**Date:** 24 September 2021

**Planning Act 2008 – Section 88 and the Infrastructure Planning (Examination Procedure) Rules 2010 – Deadline 8: Comments on 3.1 Draft Development Consent Order - Revision 8.0 and 8.17 Draft Deed of Obligation - Revision 7.0**

**Application by NNB Generation Company (SZC) Limited for an Order Granting Development Consent for the Sizewell C Project**

SECTION B - B
SCALE 1:200

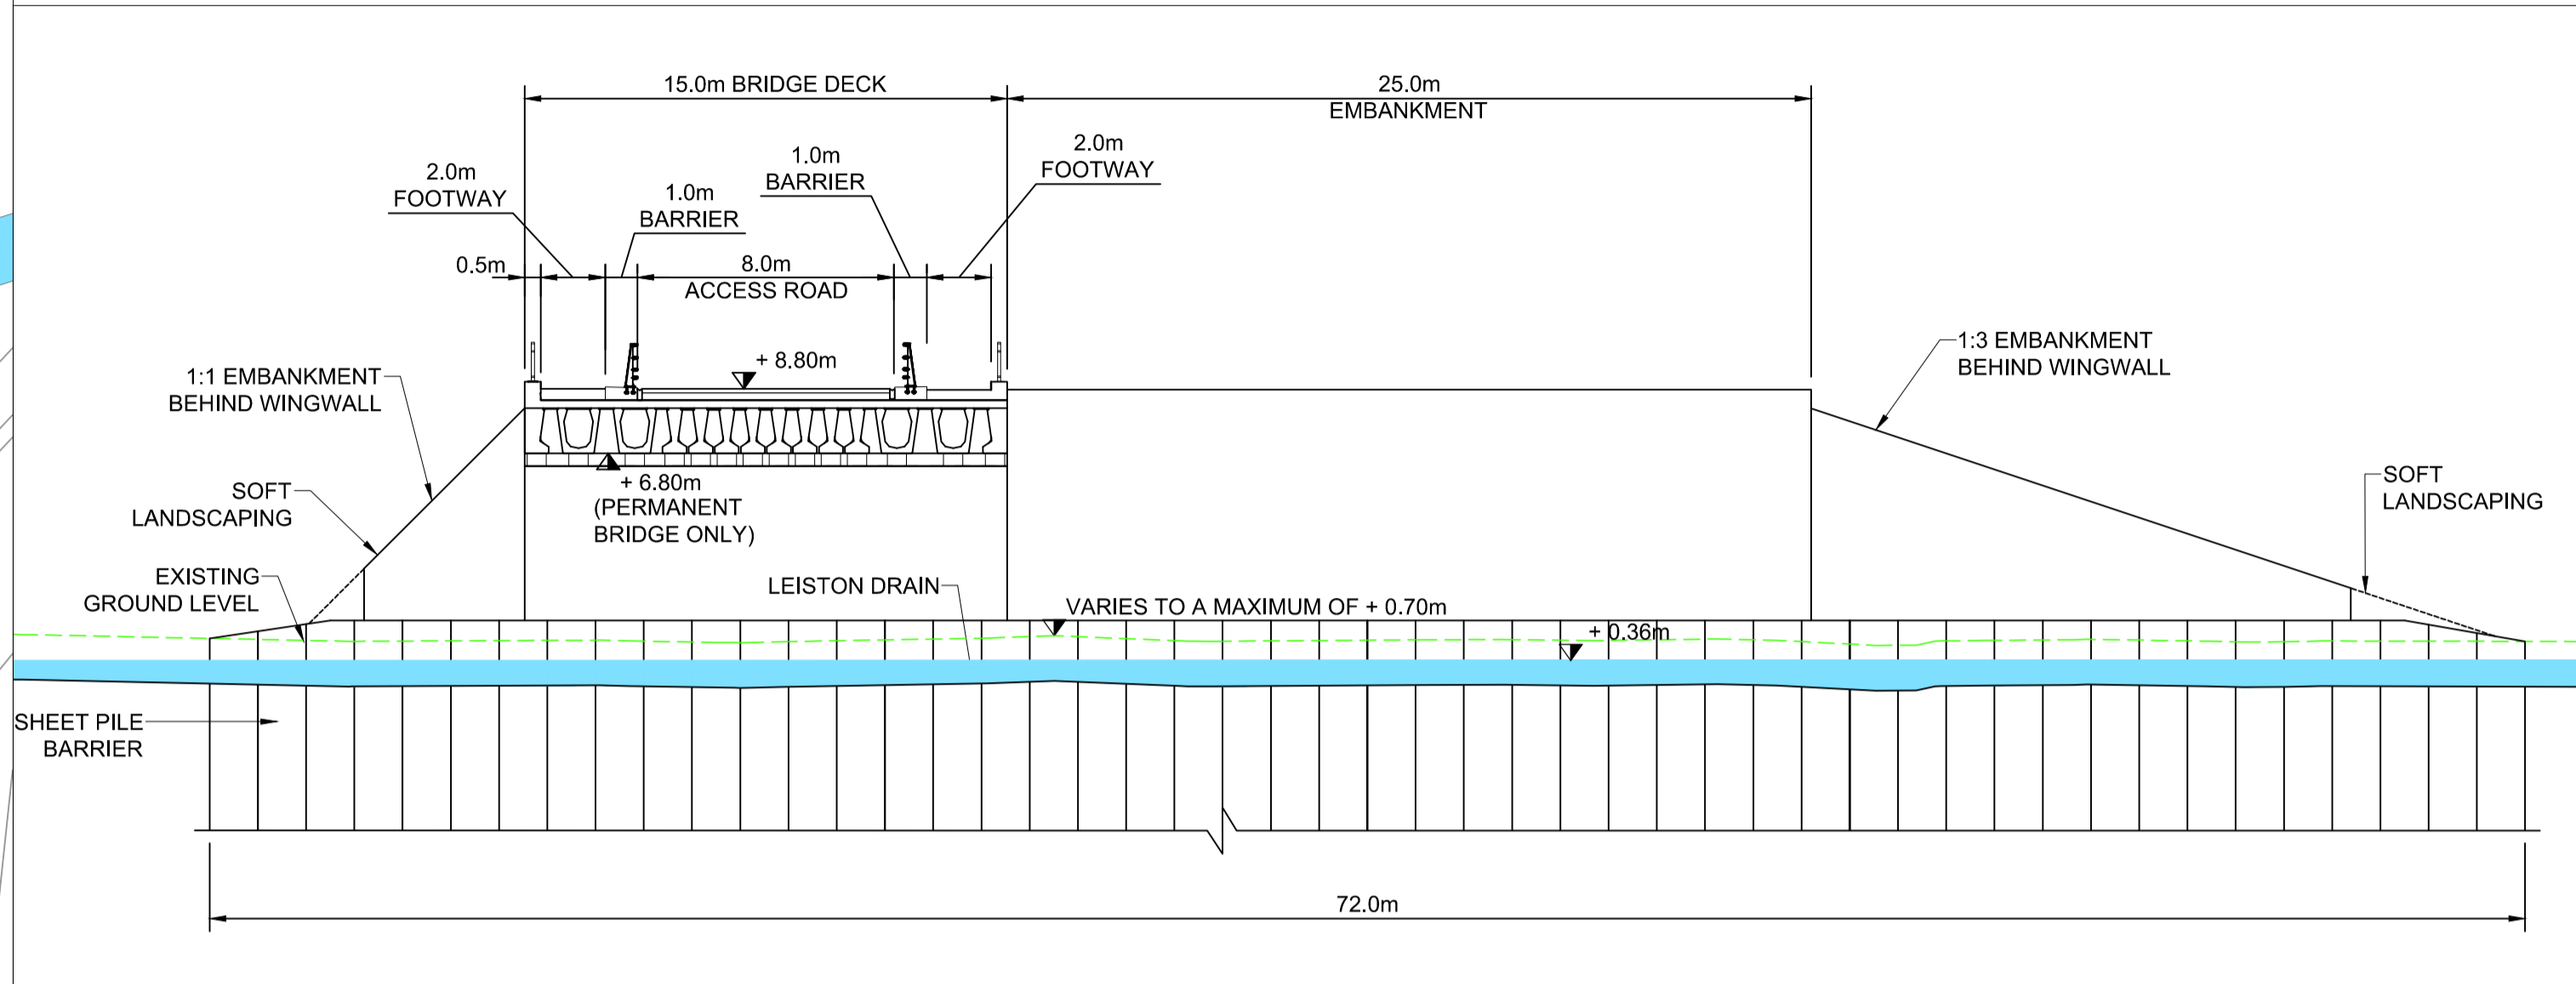
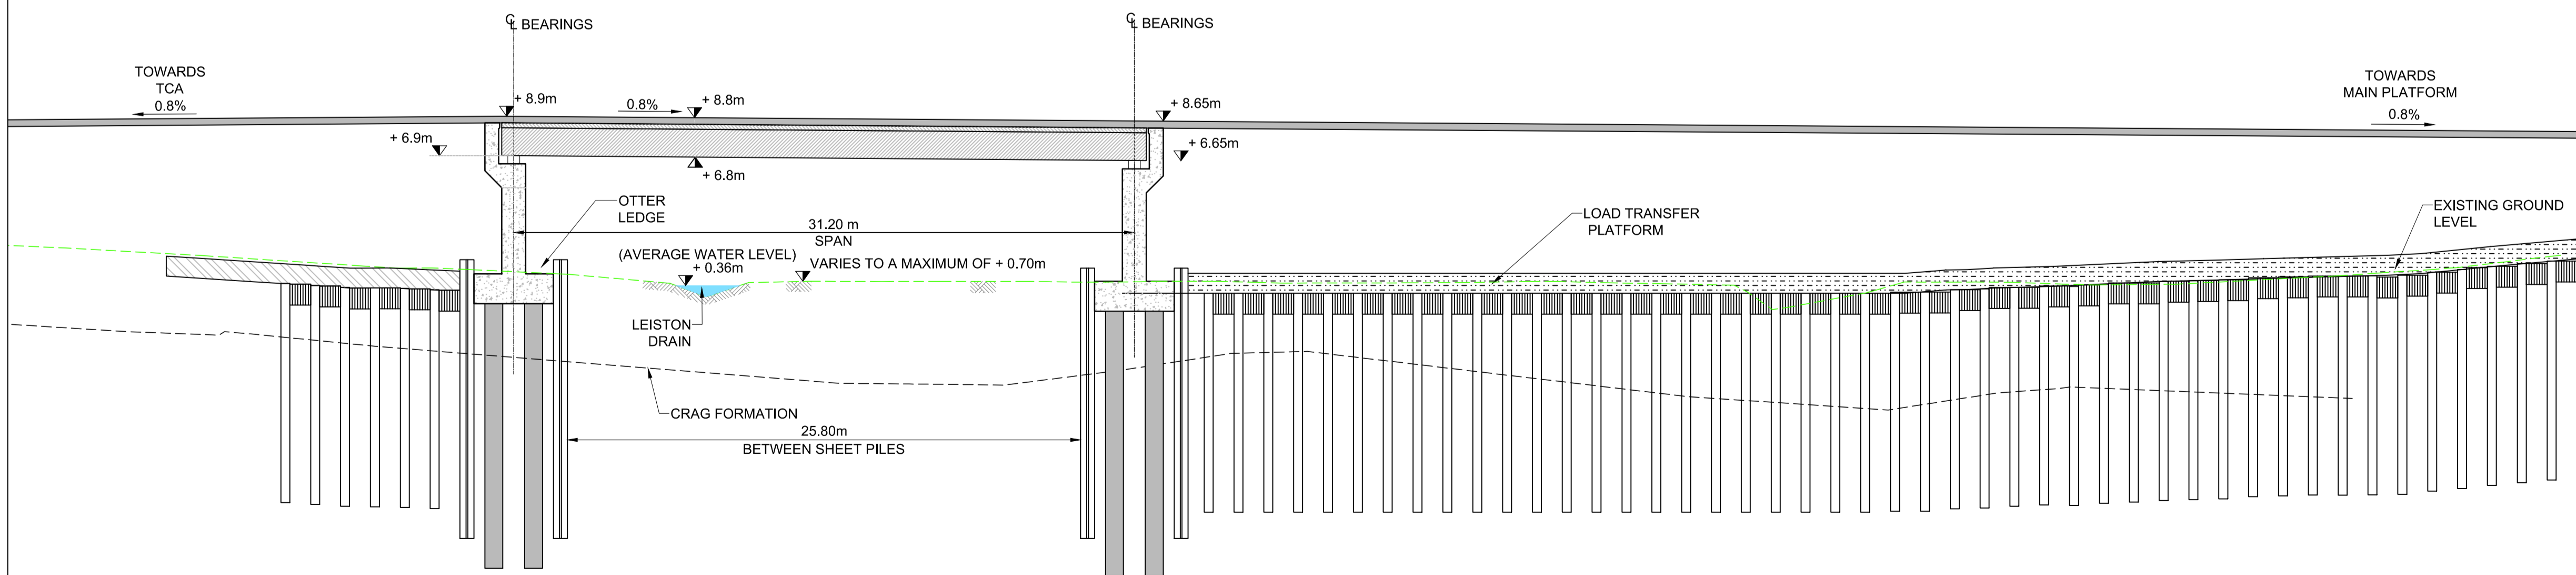
Section	Wording	Comments
<b>Schedule 2, Article 3 - Requirements</b>		
<p>Requirement 12C,</p> <p>Main development site: SSSI Crossing</p>	<p><b>Main development site: SSSI Crossing</b></p> <p>(1) Construction works within the SSSI must not commence until details of working methods within the SSSI land have been submitted to and approved by East Suffolk Council, following consultation with the Environment Agency and Natural England. The temporary SSSI Crossing must be built in general accordance with the following details:</p> <p>(a) Main Development Site SSSI Crossing (SZC Construction) (July 2021) (Drawing Ref: SZC-SZ0100-XX-000-DRW-100207);</p> <p>(b) Main Development Site SSSI Crossing (Bailey Bridge Stage) (July 2021) (Drawing Ref: SZC-SZ0100-XX-000-DRW-100209).</p> <p>(2) Construction of the permanent element of Work No. 1A(l) (SSSI Crossing) must not commence until details of the layout, scale and external appearance have been submitted to and approved by East Suffolk Council, following consultation with the Environment Agency and Natural England. The details must:</p> <p>(a) be in general accordance with the Main Development Site SSSI Crossing (SZC Operational) (July 2021) (Drawing Ref: SZC-SZ0100-XX-000-DRW-100205);</p> <p>(b) include layout and scale which has:</p> <p>(i) a crest no lower than 8.6m (AOD);</p>	<p>The potential environmental impacts, including Water Framework Directive concerns, relate to both the construction and permanent elements of the SSSI Crossing.</p> <p>We welcome that the Environment Agency is now proposed as a consultee in discharging (1) Construction works, as well as for (2) permanent elements.</p>

<p>(ii) a soffit no lower than 6.8m (AOD) at its intersection with the Leiston Drain; and</p> <p>(iii) a span no wider than 15m.</p> <p>(c) include a flood risk monitoring and adaptive defence plan that sets out the periodic monitoring proposals for the SSSI Crossing and the trigger point for when the crest height of the SSSI Crossing would need to be increased to 10.5m (AOD).</p> <p>(d) a timetable for the works, including a timetable for the return of temporary SSSI land.</p> <p>(3) Work No. 1A(I) (SSSI Crossing) must be carried out in accordance with the approved details.</p>	
<p>Requirement 22A,</p> <p>Associated developments: Landscape works</p>	<p><b>Associated developments: Highway landscape works</b></p> <p>(1) Work No. 11 and Work No. 12 must not be commenced until details of the landscape works for that work have been submitted to and approved by East Suffolk Council in consultation with the Environment Agency.</p> <p>(2) The details referred to in paragraph (1) must be in accordance with the Approved Plans (Schedule 7), unless otherwise agreed by East Suffolk Council.</p> <p>(3) Landscape works must be carried out in accordance with the approved details.</p> <p>(4) Landscape works in relation to Work No. 11 must be managed in accordance with the Two Village Bypass Landscape and Ecology Management Plan, unless otherwise agreed with East Suffolk Council.</p>	<p>This requirement secures key environmental mitigation and monitoring measures.</p> <p>We welcome that the Environment Agency is now proposed as a consultee for any future revision of Sizewell Link Road or Two Village Bypass Landscape and Ecology management plans.</p>
